From: [REDACTED]
To: [Norfolk Boreas](#)
Subject: Deadline Five
Date: 11 February 2020 18:16:31

In the Applicants Document No. ExA.ISH3.D4.V1 (EN010087-001588-Written Summary) page 18, the Applicant quotes heights of the on-shore sub-station buildings and masts, etc, to be relative to the existing ground level, quote "(5) Buildings comprised in Work No. 8A must not exceed a height of 19 metres above existing ground level and external electrical equipment comprised in Work No. 8A must not exceed a height of 25 metres above existing ground level", unquote.

Requirement 16 (5)
Buildings must not exceed 19m

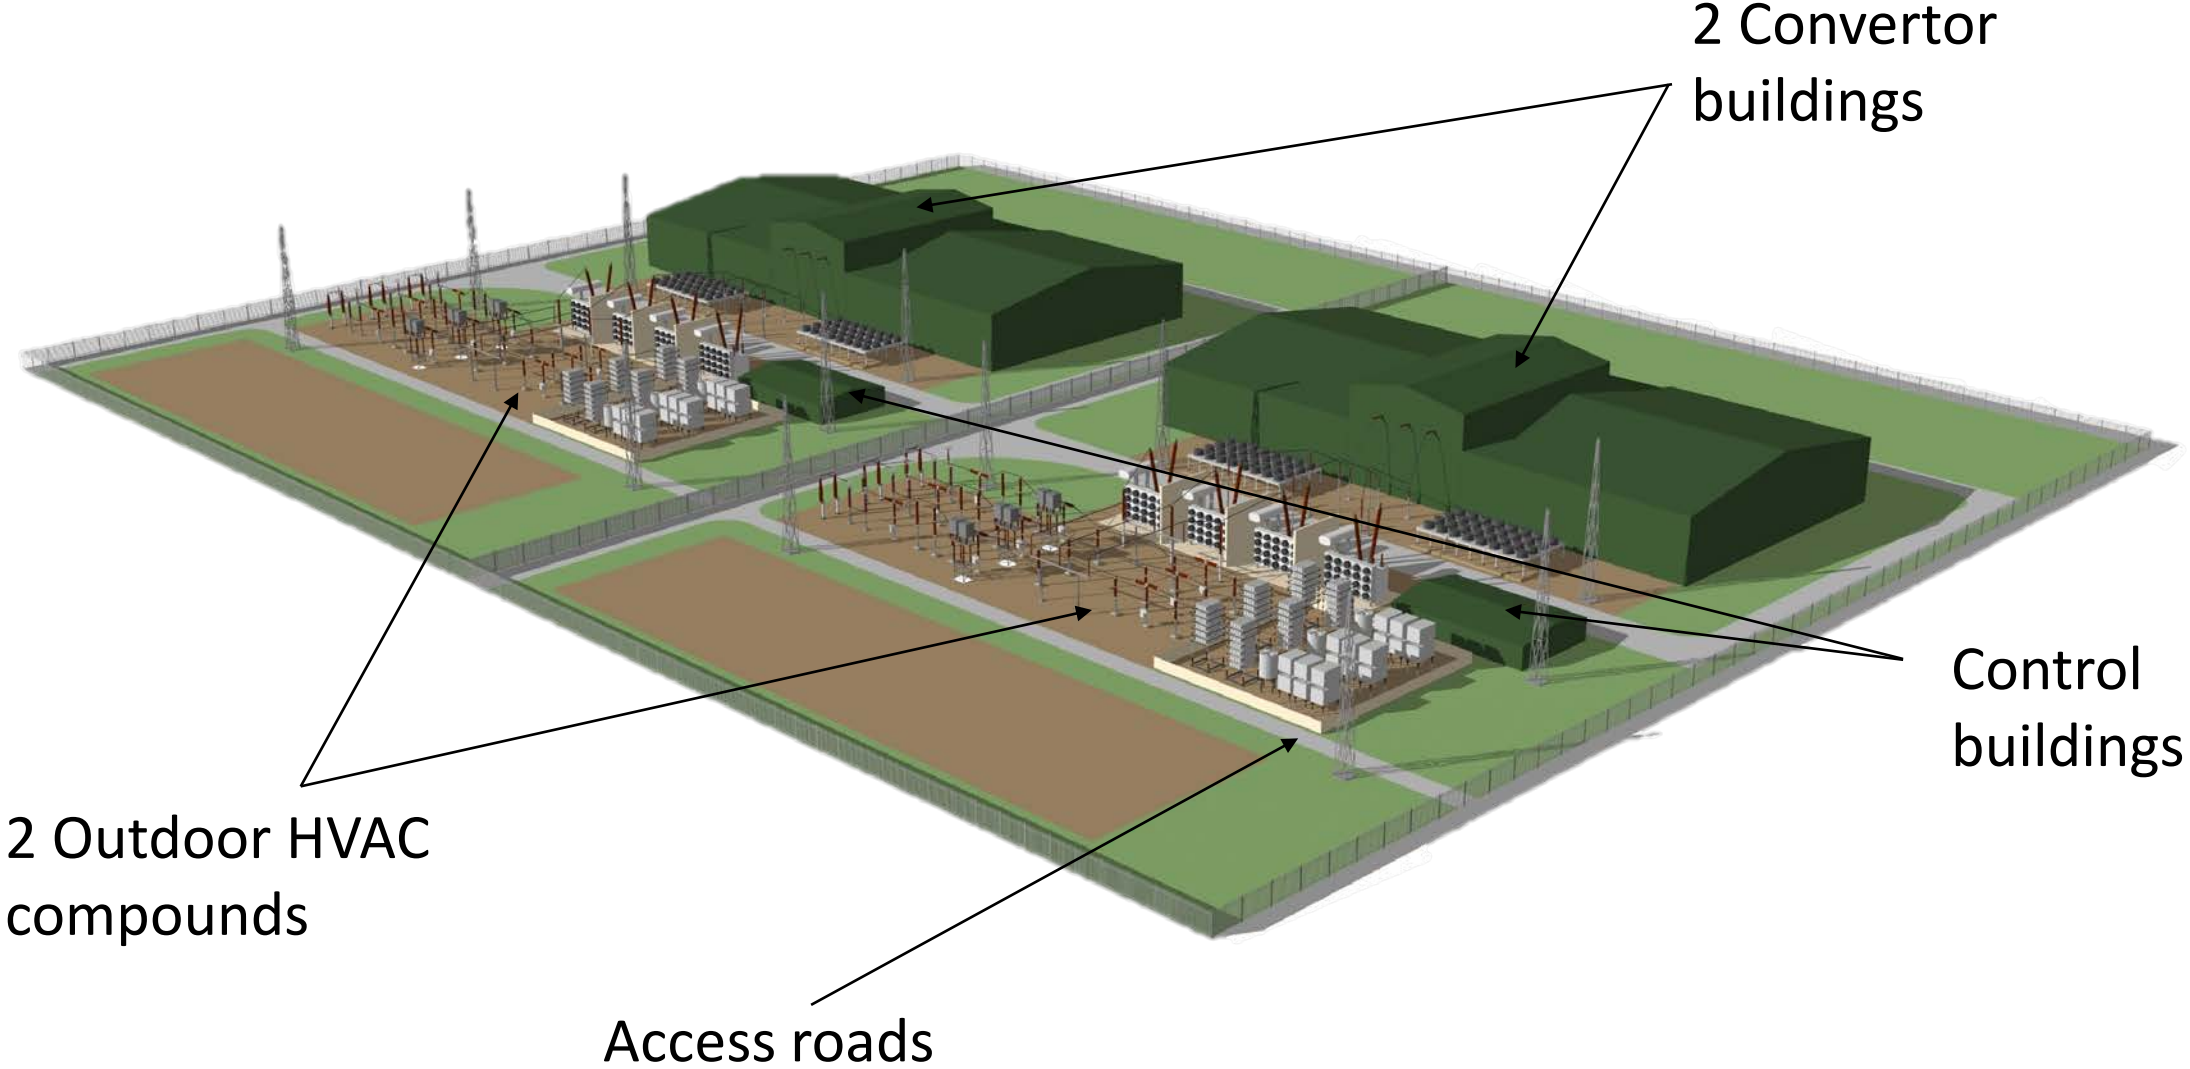
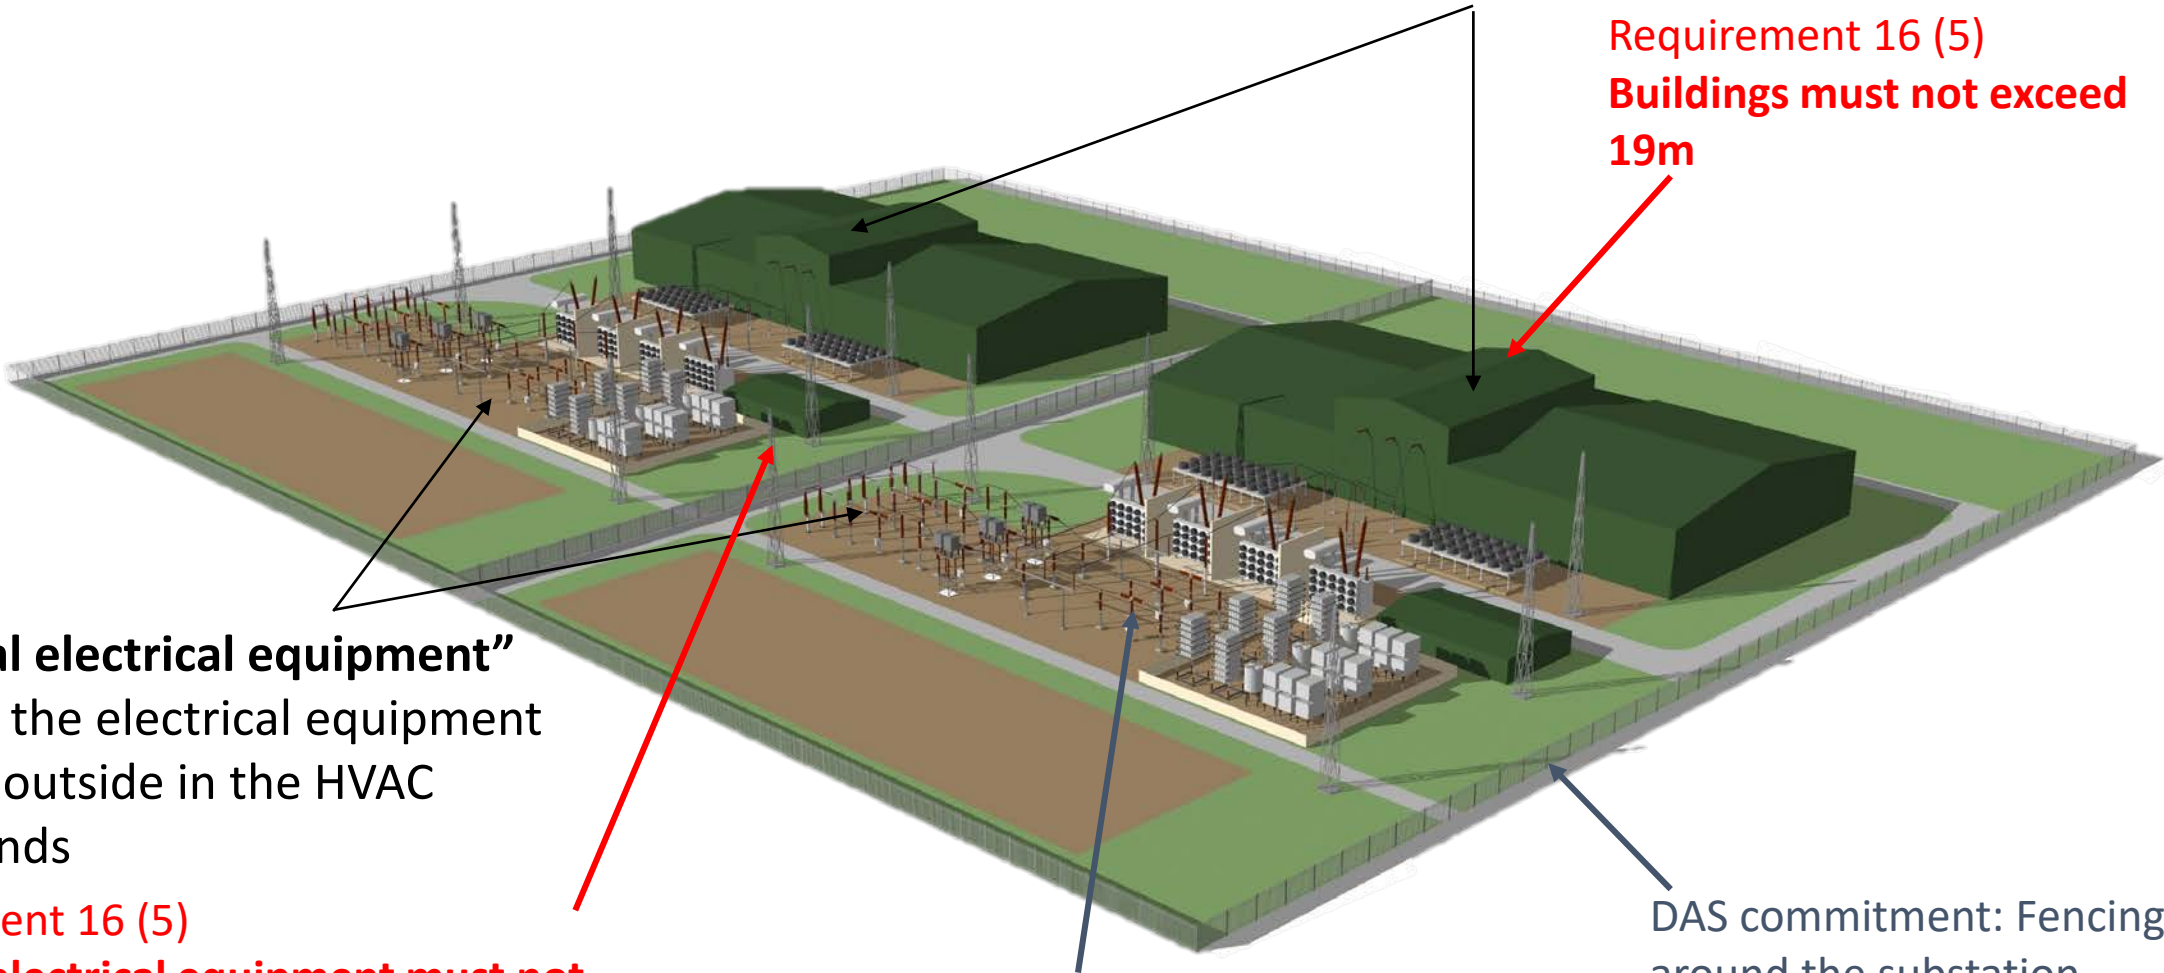
Given that a certain amount of civil engineering must take place for footings, foundations and floor levels, etc, will the Applicant give a written undertaking that such works will not result in a base level for their equipment that is higher than the existing ground level. If such base levels are higher than the existing ground levels it follows that their equipment will be higher than that stated from the existing ground level and of course more visible than predicted on photomontages, etc.

Necton has already experienced this with the existing Dudgeon sub-station whereby an error with the civils work for the buildings and equipment resulted in a higher than designed/stated base. This means the site is more visible than predicted.

This matter is a high priority as any mistake will remain visible for the whole lifetime of the sub-station.
